Berry, Huff, McDonald, Milligan Inc.
Engineers, Surveyors

August 29, 2012

RE: Level I-Minor Residential Development Review Site Plan Revisions
Level II-Preliminary & Final Site Plan Development Revisions
Chabad Lubavitch of Maine LLC.
Pomeroy Street

Level I&II Revisions-8-29-2012

SHEET
1
 REPRODUCTION OR REUSE OF THIS DOCUMENT WITHOUT THE EXPRESSED WRITTEN CONSENT OF BH2M INC. IS PROHIBITED

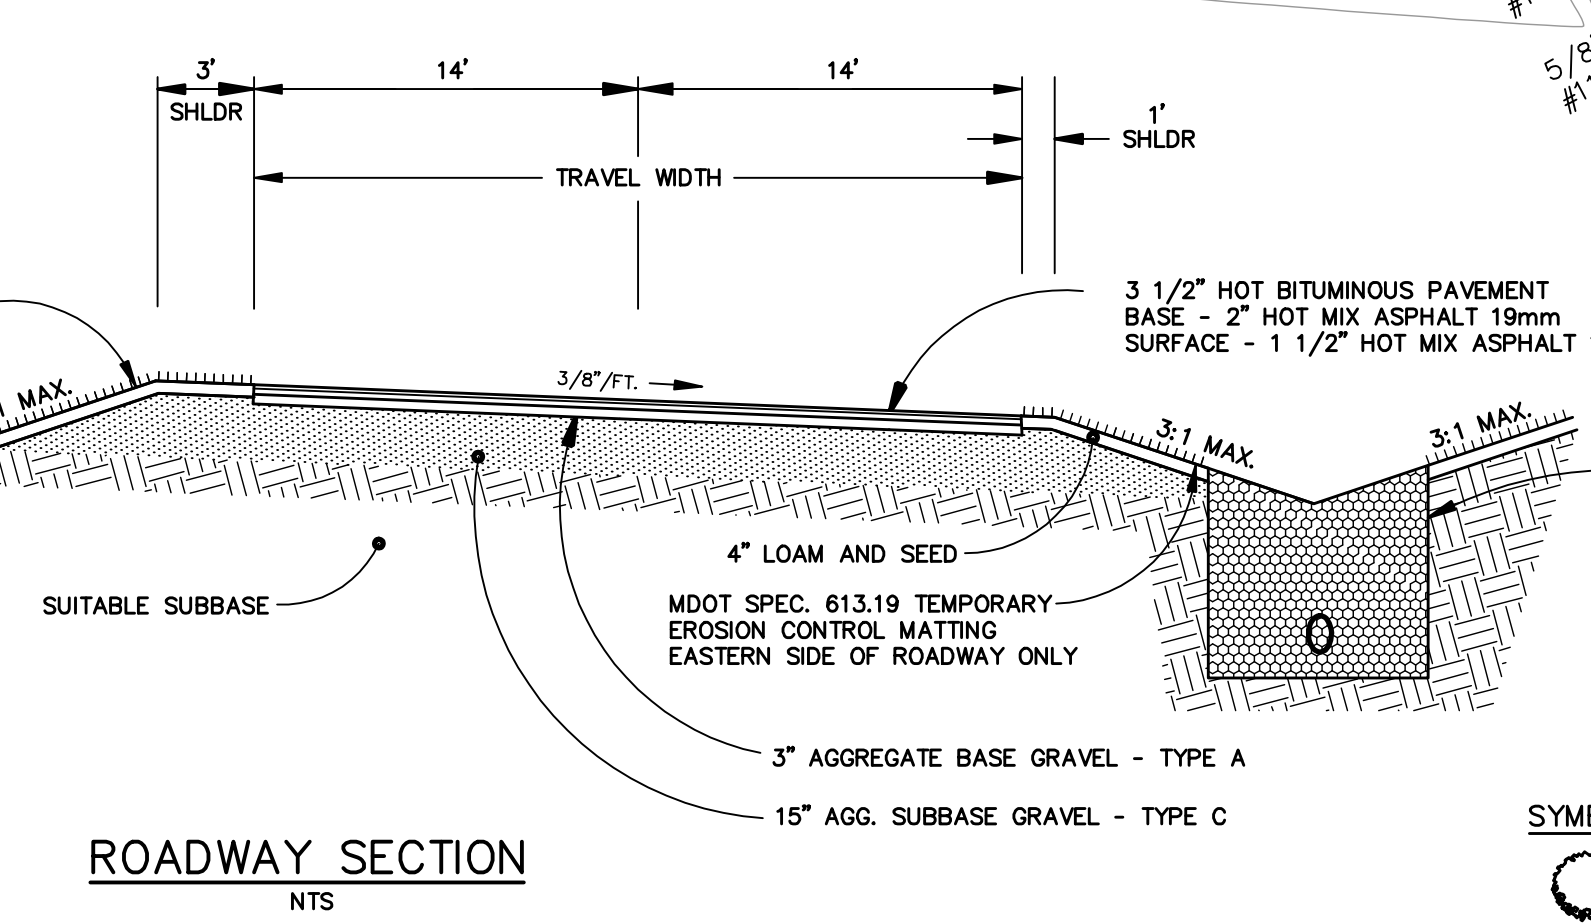
2. Note #23 has been added to the Site Plan (Sheet 1).
3. As discussed above some of the existing trees will be preserved, however, there have also been 4 street trees proposed along Pomeroy Street as part of these improvements as well (see Plans for more information). As part of these revisions some additional site landscaping has been proposed (see sheet 1 for additional information).

1. The plans have been revised as requested and summarized below:
 - a. Distance from proposed buildings to property lines has been added to the Site Plan (Sheet 1).

- b. Note #24 has been added to the Site Plan to summarize the area of disturbance. A limit of disturbance line has also been added to the plans for clarity.

- c. A foundation drain has been added to the Site Plan. A detail has also been added to sheet 4 of the plans.
 - d. Note #25 has been added to the Site Plan regarding the preservation of existing trees.

3. The easement around the existing trees abutting land of Kriston Briggs & Jean Gilpatrick is a proposed easement not an existing easement. More details have been added to the Site Plan for this easement.

1. See Comment 1 From Environmental Section of Nell Donaldson's Review Comments above.
2. A detail was added to sheet 4 of the plans.
3. Note #26 has been added to the Site Plan (Sheet 1) regarding the construction of Pomeroy Street.

4. The turnaround has been defined with the appropriate easements as requested (see sheet 1 of the plans).
5. The detail on sheet 4 has been revised accordingly.

6. The details on sheet 4 have been revised accordingly.
7. A detail of the truncated dome proposed as part of this project has been added to Sheet 1 for review by the City and Mr. Hyman.

8. We look forward to hearing from the City on this item.
9. Note #28 has been added to the Site Plan regarding the street status.
10. The plans have been revised to be on the Maine State Coordinate System as requested. Coordinate References have been added to the Site Plan.

11. The project Benchmark has been revised as requested (see Sheet 1).
12. Our office has not heard from counsel on this item to date.
13. The portion of Pomeroy Street to be accepted as part of this project has been revised to include all appropriate information as requested (see Sheet 1).

1. Note #27 has been added to the Site Plan (Sheet 1).
2. This information will be forwarded to the City once received by our office.
3. See Comment 1 from Environmental Section of Review Comments by Nell Donaldson above.

SHEET  
**3**

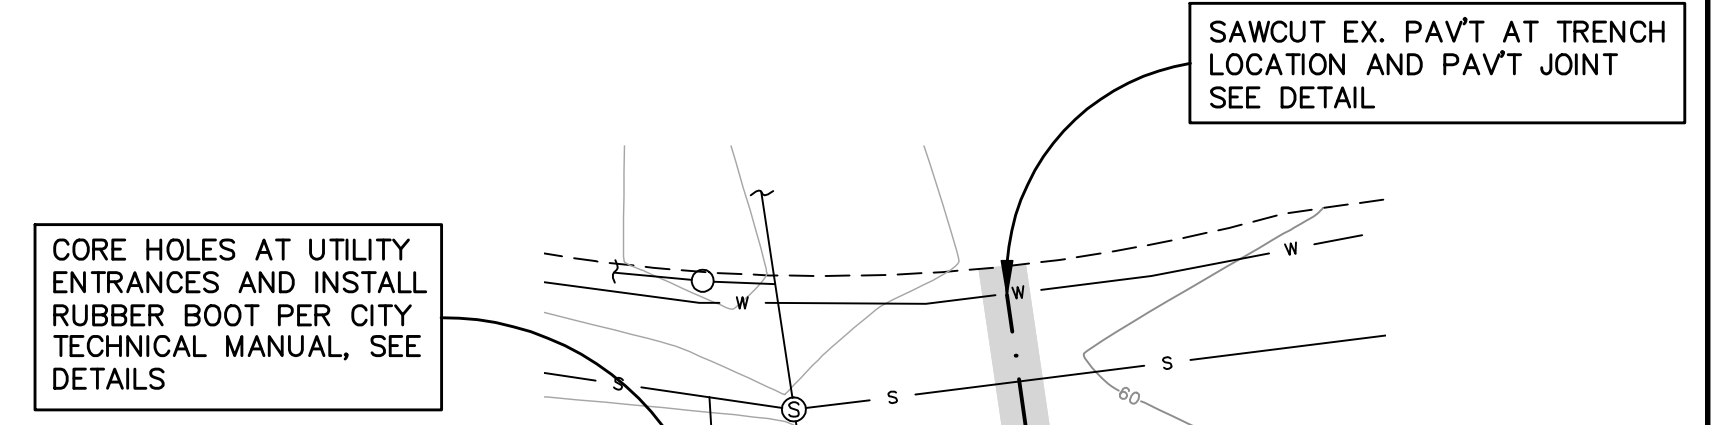
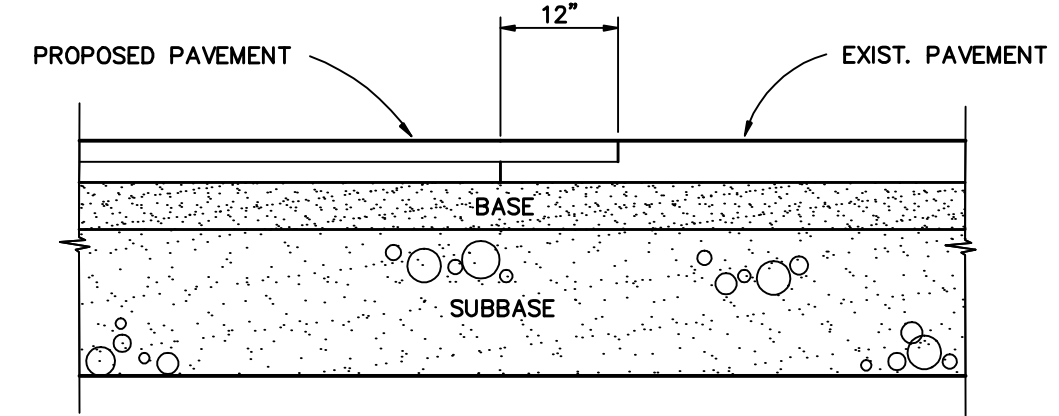
4. To comply with City standards the following changes have been made to the plans:
 - a. The Roadway Section Detail on Sheet 3 of the plans has been revised accordingly.

PRE DEVELOPMENT  
DRAINAGE PLAN  
LAND OF  
CHABAD LUBOBITCH OF MAINE INC.  
POMEROY STREET  
PORTLAND, MAINE

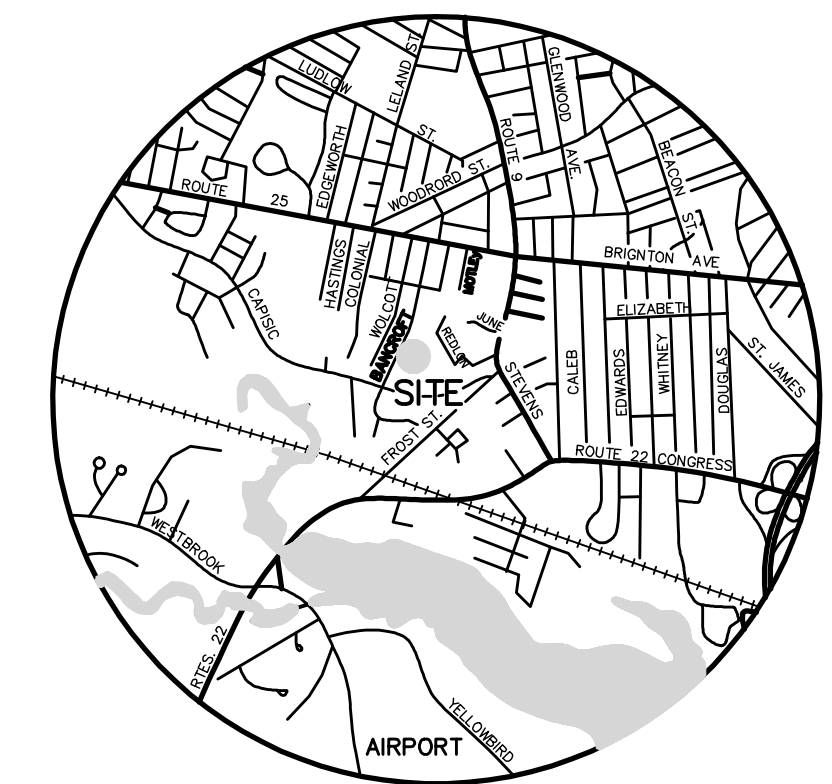
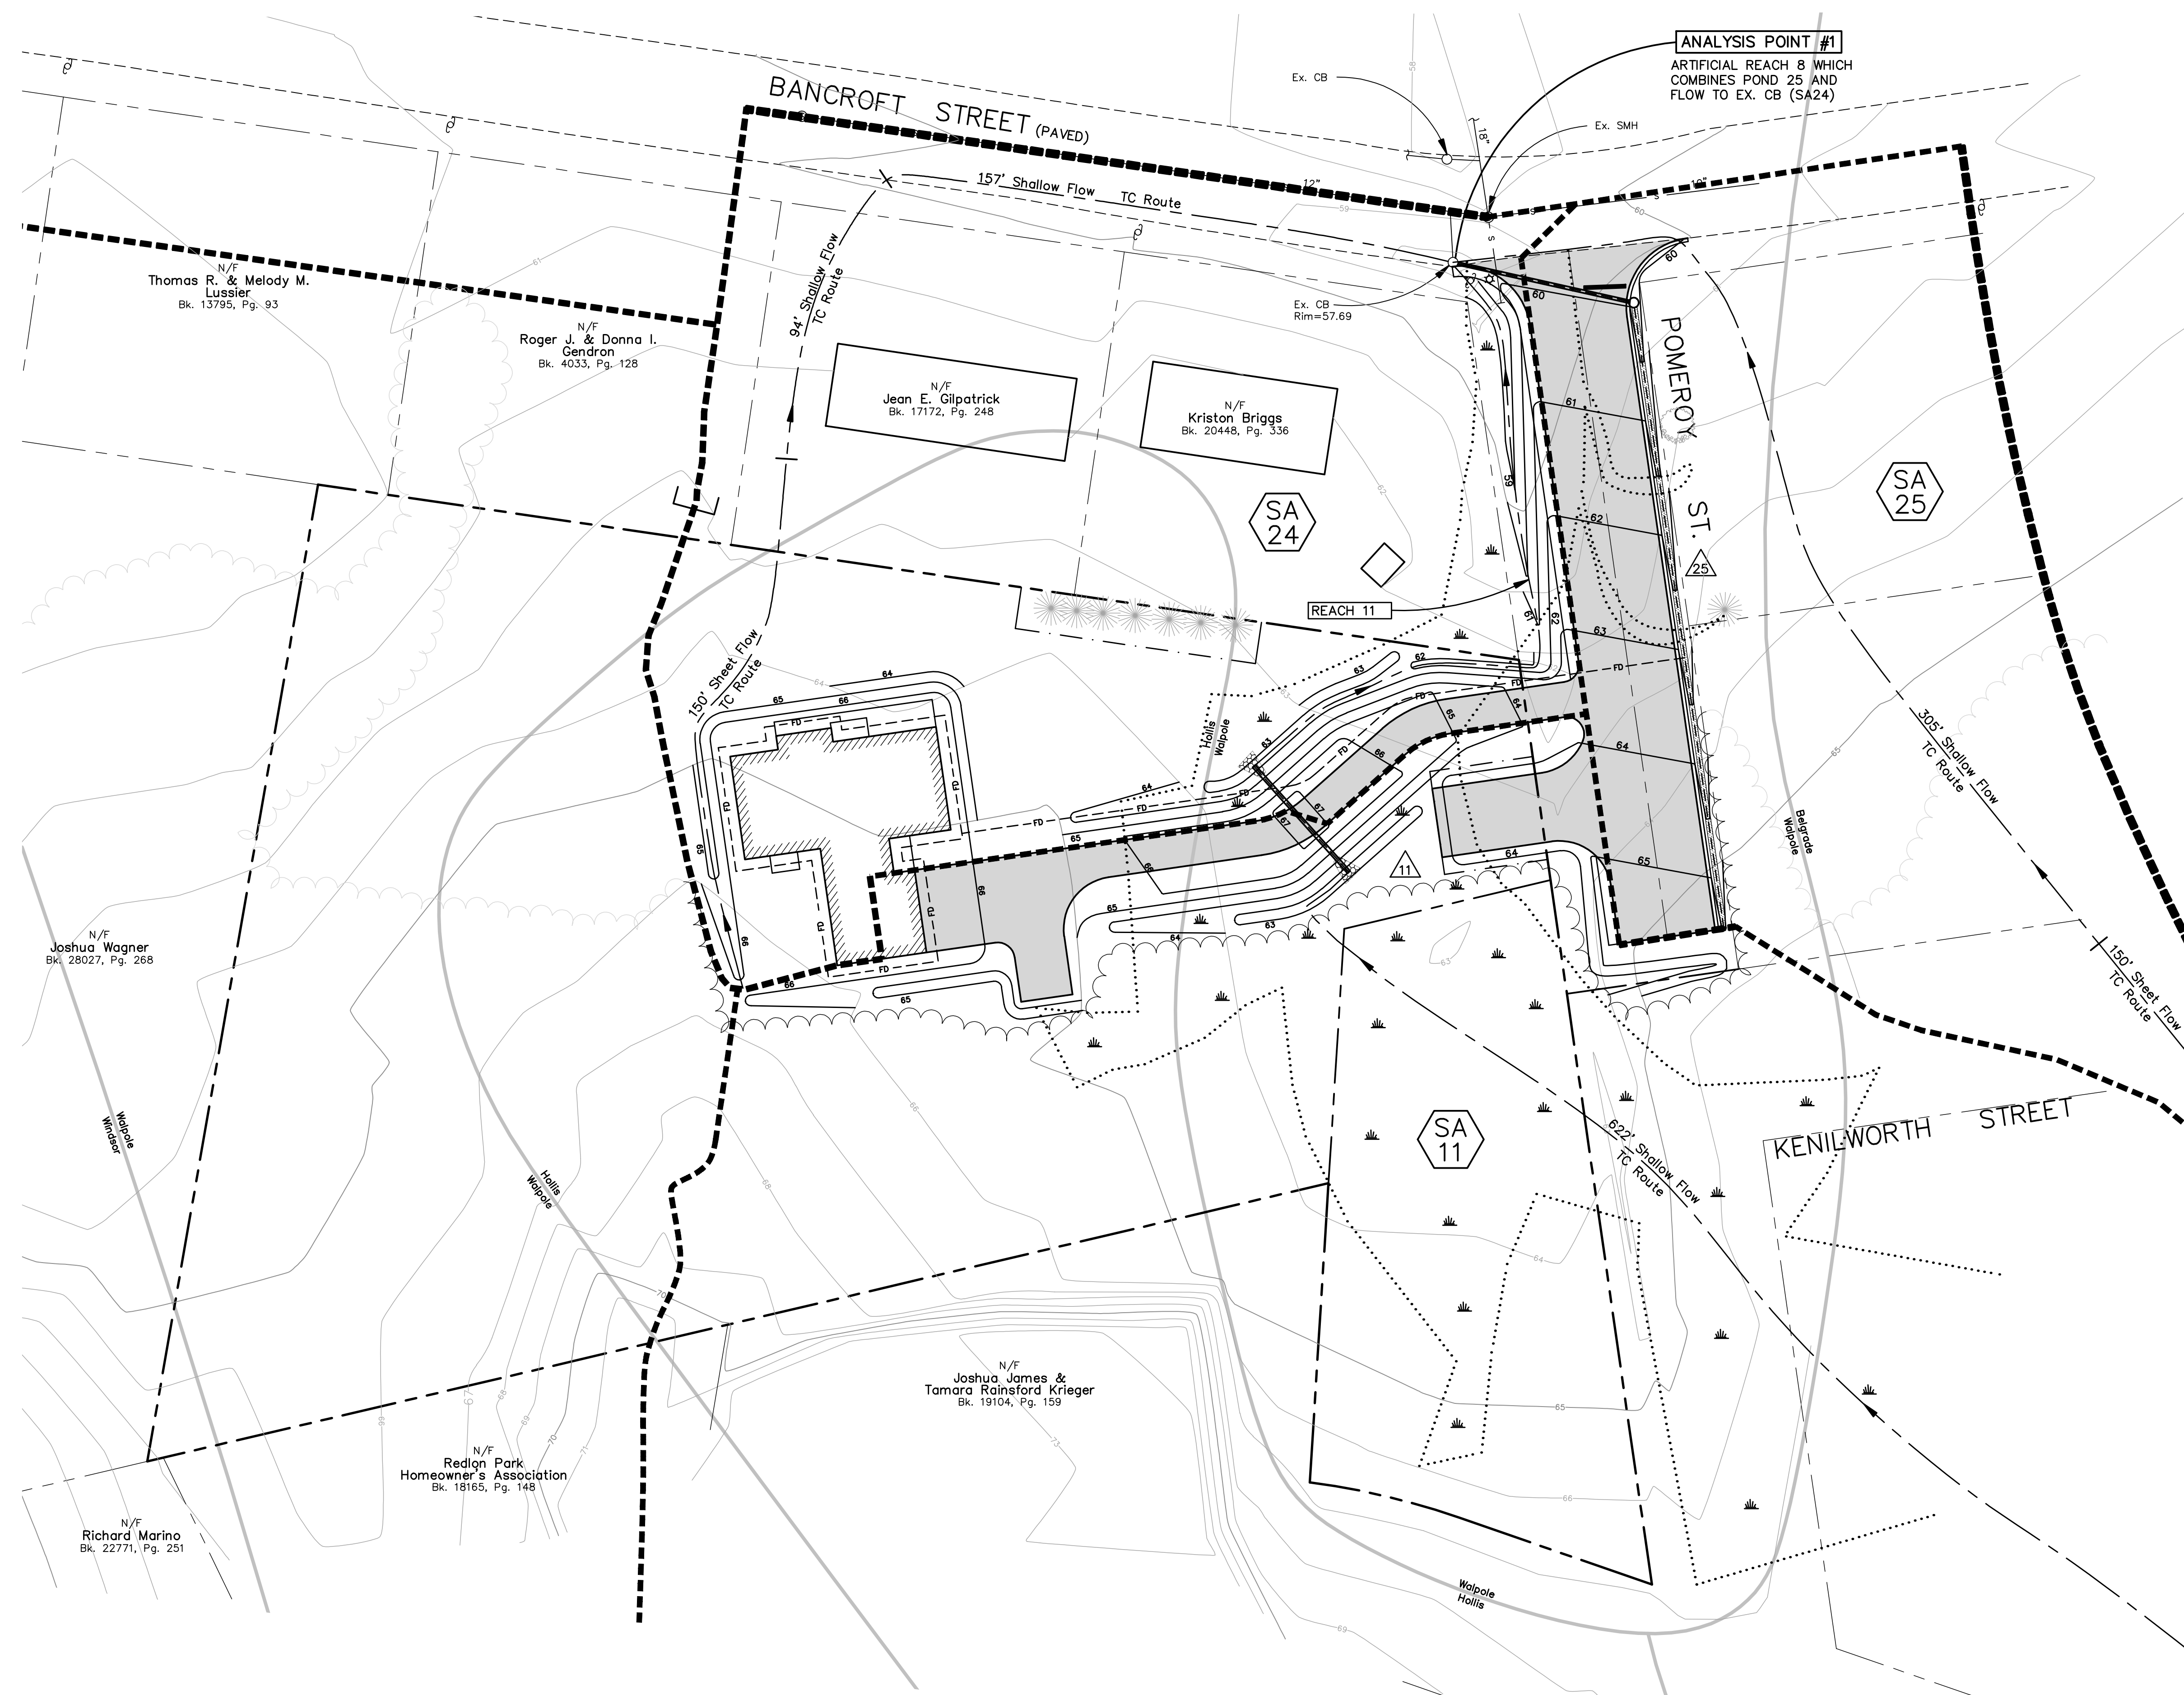
6. The applicant requests to pay the Urban Impaired Stream Compensation Fees as part of this project.
7. A review of the Drainage Plans (Sheets 6 through 8) will show that Subcatchment 1 within the Pre Development condition shall in fact differ in both ground cover and time of concentration route from Subcatchment 11 within the Post Development condition since this is where the Single Family residential home, driveway and other site improvements have been proposed as part of this project.
